June 14, 2004

RE: Drake Equipment Addition, 160 Presumpscot Street
ID #2004-0101, CBL #425-K-001

On June 4, 2004, the Portland Planning Authority approved a 1,300 sq. ft. connector building to be located at 160 Presumpscot Street as shown on the approved plan with the following conditions:

F.P. DRAKE
DRAKE EQUIPMENT CO.
160 PRESUMPCOT ST.
PORTLAND, MAINE
BUILDING ADDITION PROJECT
SITE PLAN

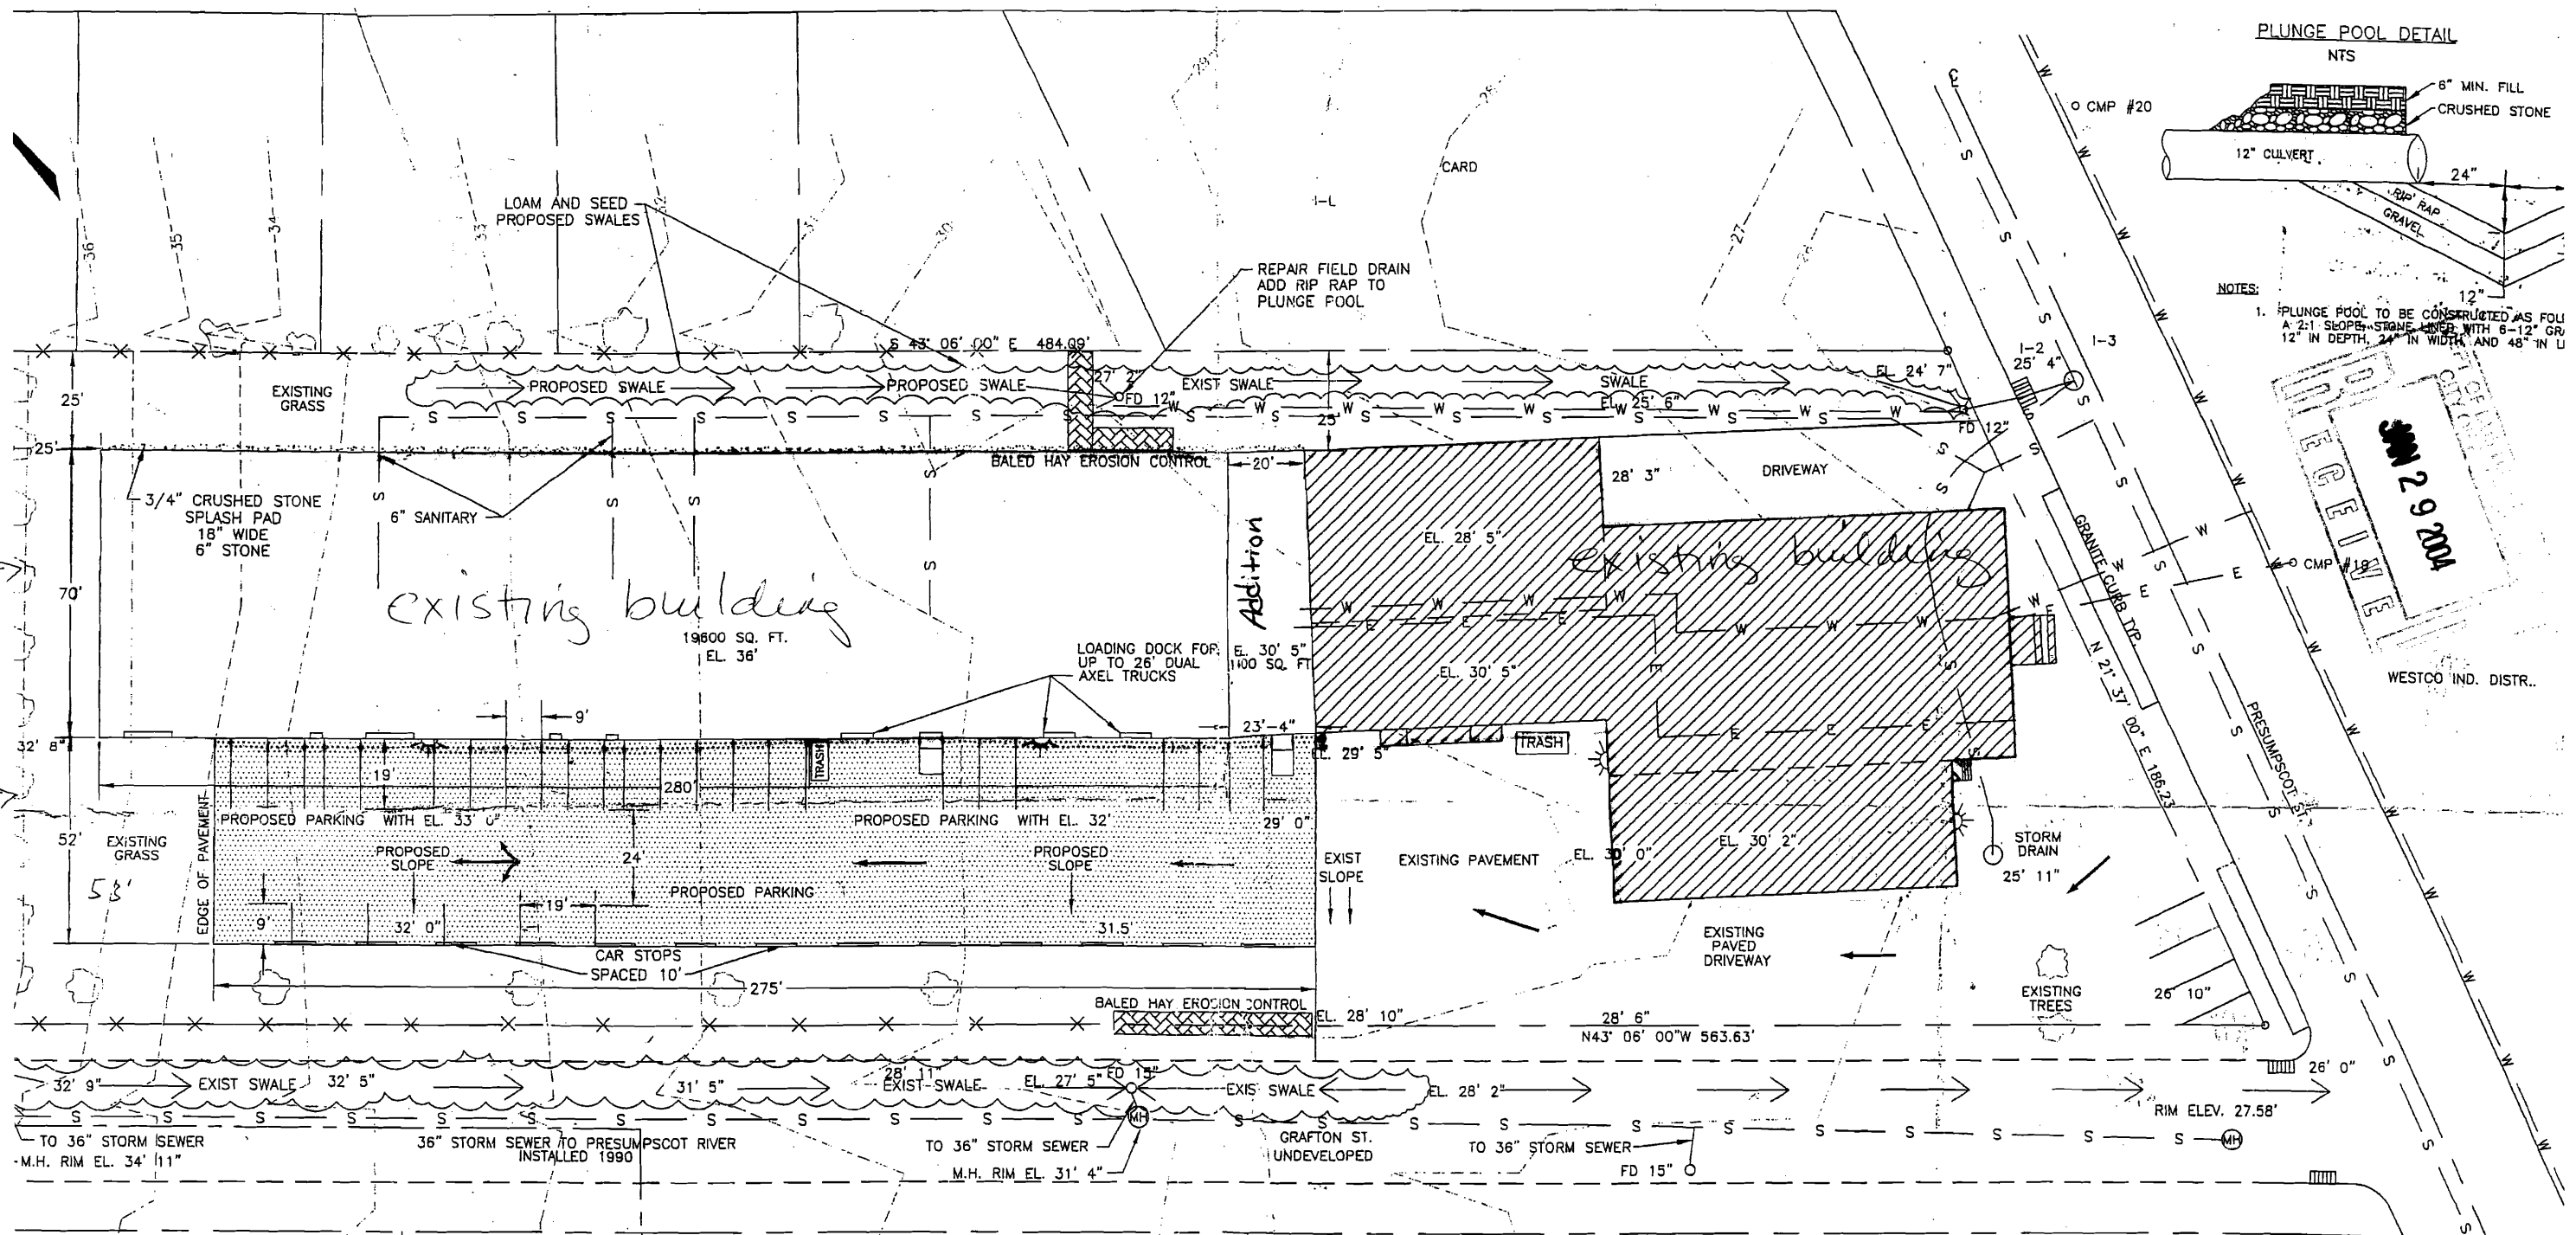
- i. Since the plan shows access through the site from Presumpscot Street, staff is requiring that a steel guardrail, shall be installed along the Grafton Street entrance of the site. If the applicant does not wish to close off the Grafton Street access, then the applicant must pave a driveway over Grafton Street to the site and revised plans shall be submitted to staff.
- ii. The applicant shall install five (5) street trees, species and spacing to be approved by the City Arborist, within the esplanade along the Presumpscot Street frontage.
